**CITY OF ALBUQUERQUE
PLANNING DEPARTMENT
Development Review Board
July 14, 2004 Comments**

PROJECT # 1002328 APPLICATION # 04-01062

Re: Lot 2, Block 3, Row 1, Unit B, Town of Atrisco Grant/sketch

DEVELOPMENT REVIEW BOARD--SPEED MEMO

NEW MEXICO QUALITY CONSULTANTS  
 CONSTRUCTION MANAGEMENT, SURVEYING & CIVIL ENGINEERING  
**GRADING & DRAINAGE PLAN**  
 A-1 FIREWOOD INC  
 1016 SAN PEDRO DR. NE ALBUQUERQUE, NEW MEXICO 87110 PH: 505-710-3099 FAX: 505-254-4952

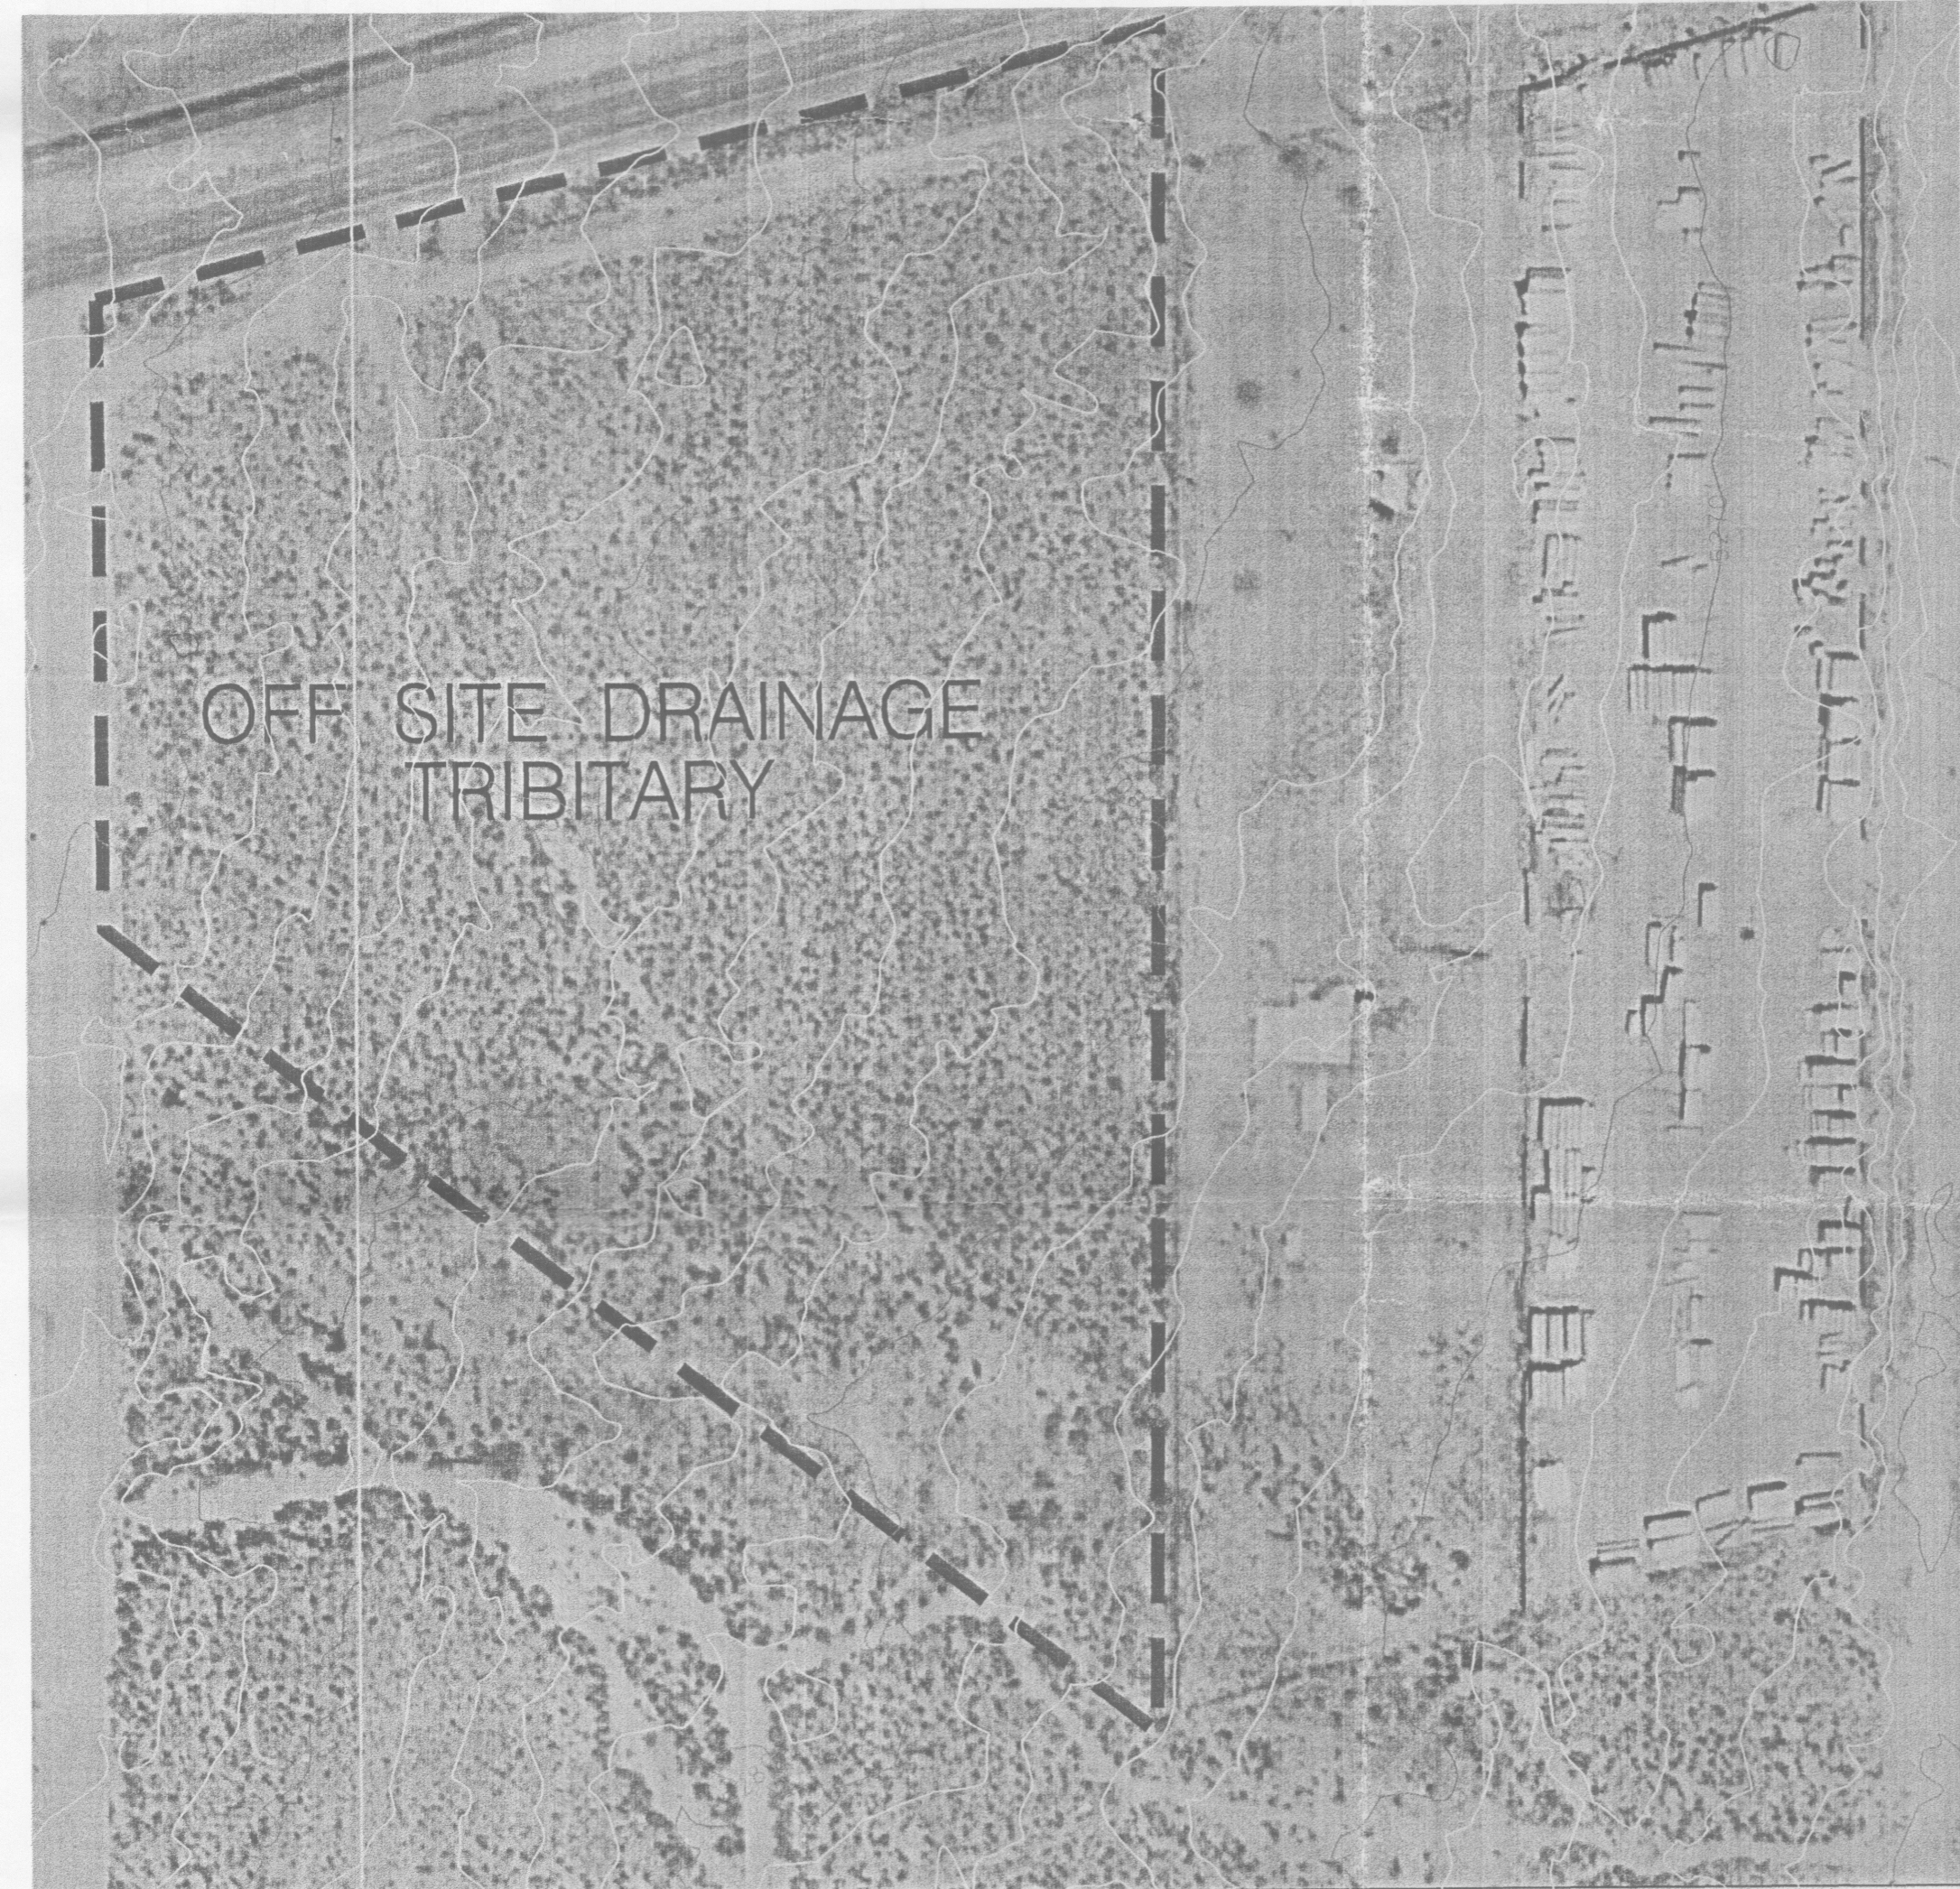
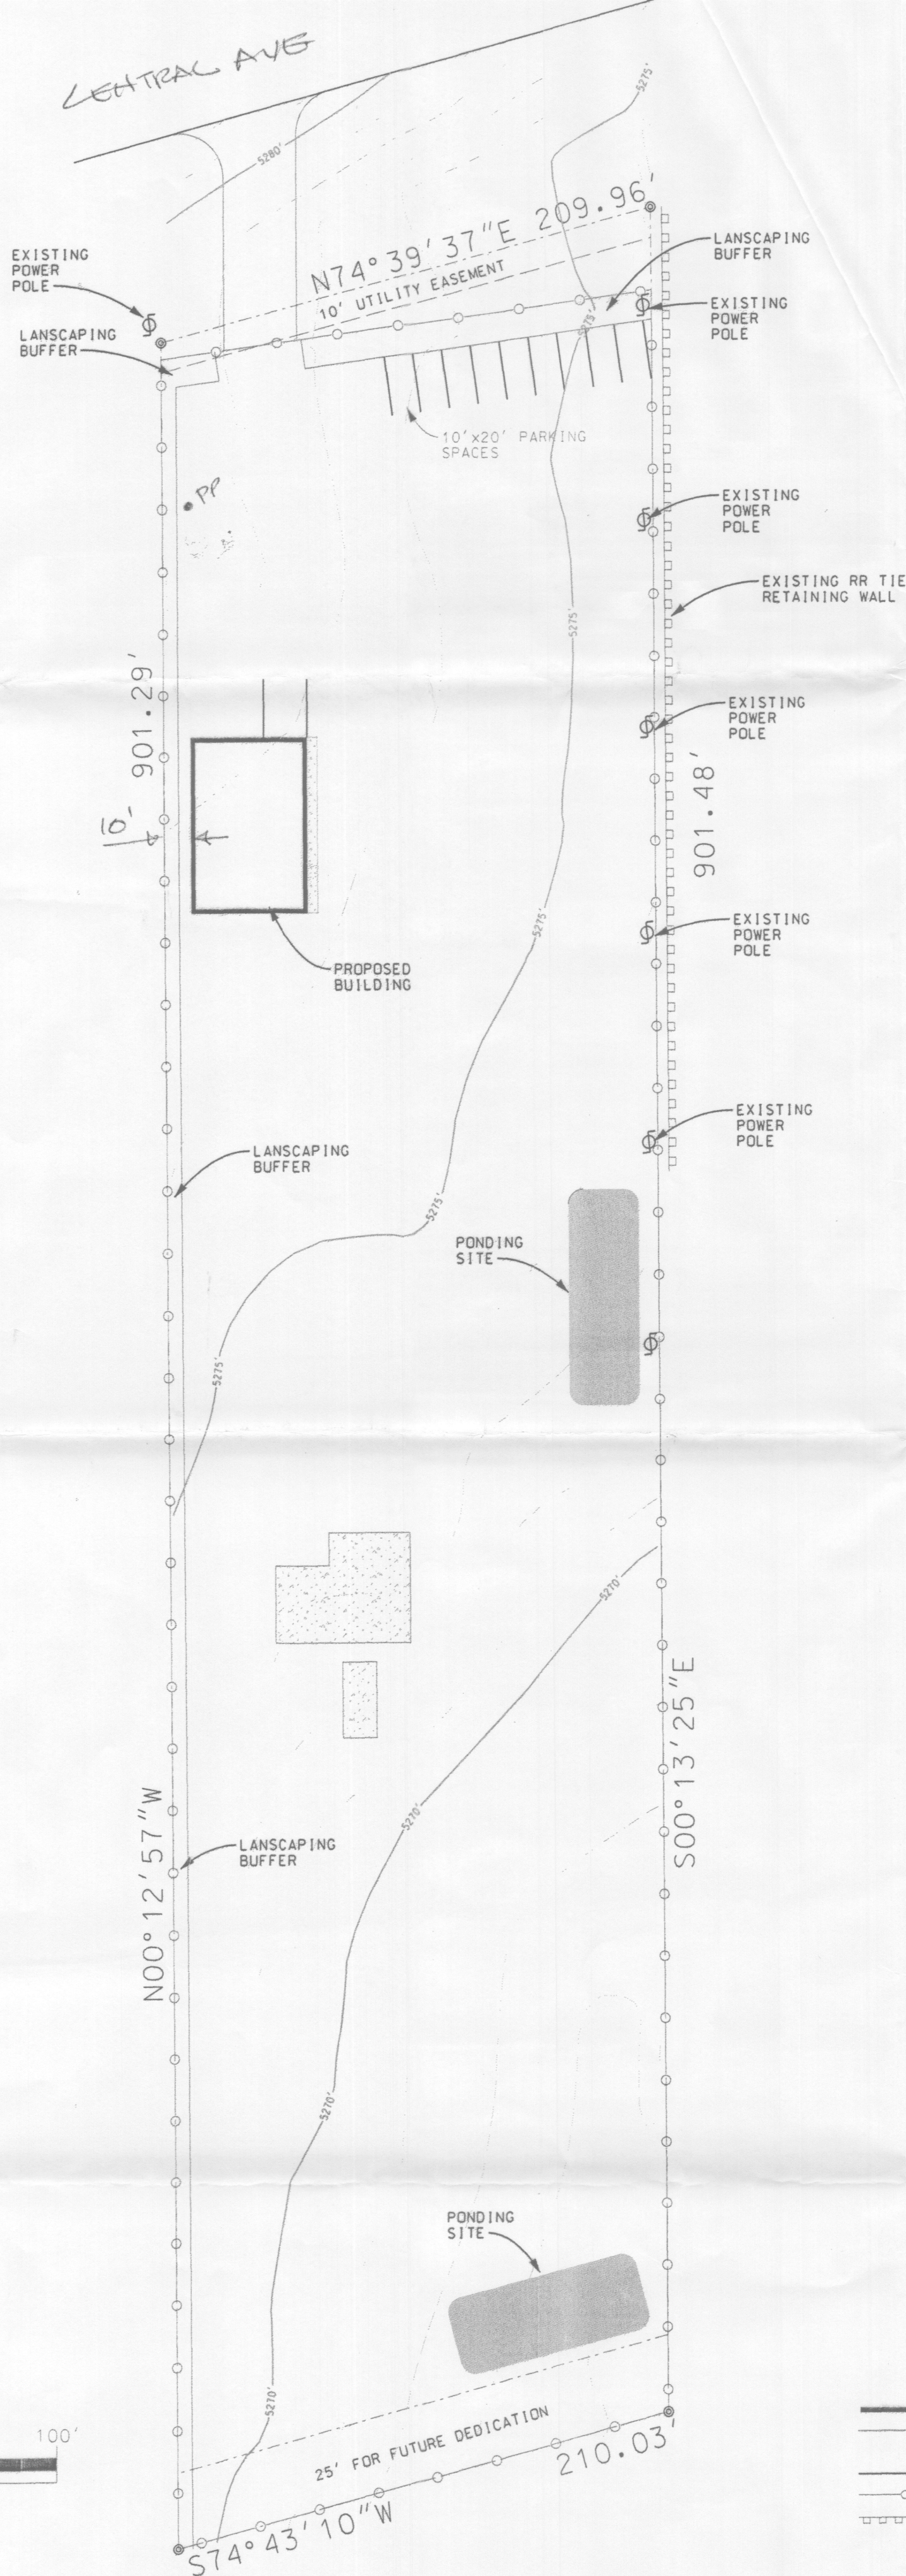
An approved conceptual grading and drainage plan is required for site plan sign-off by the City Engineer
An approved infrastructure list is required for Site Plan approval.
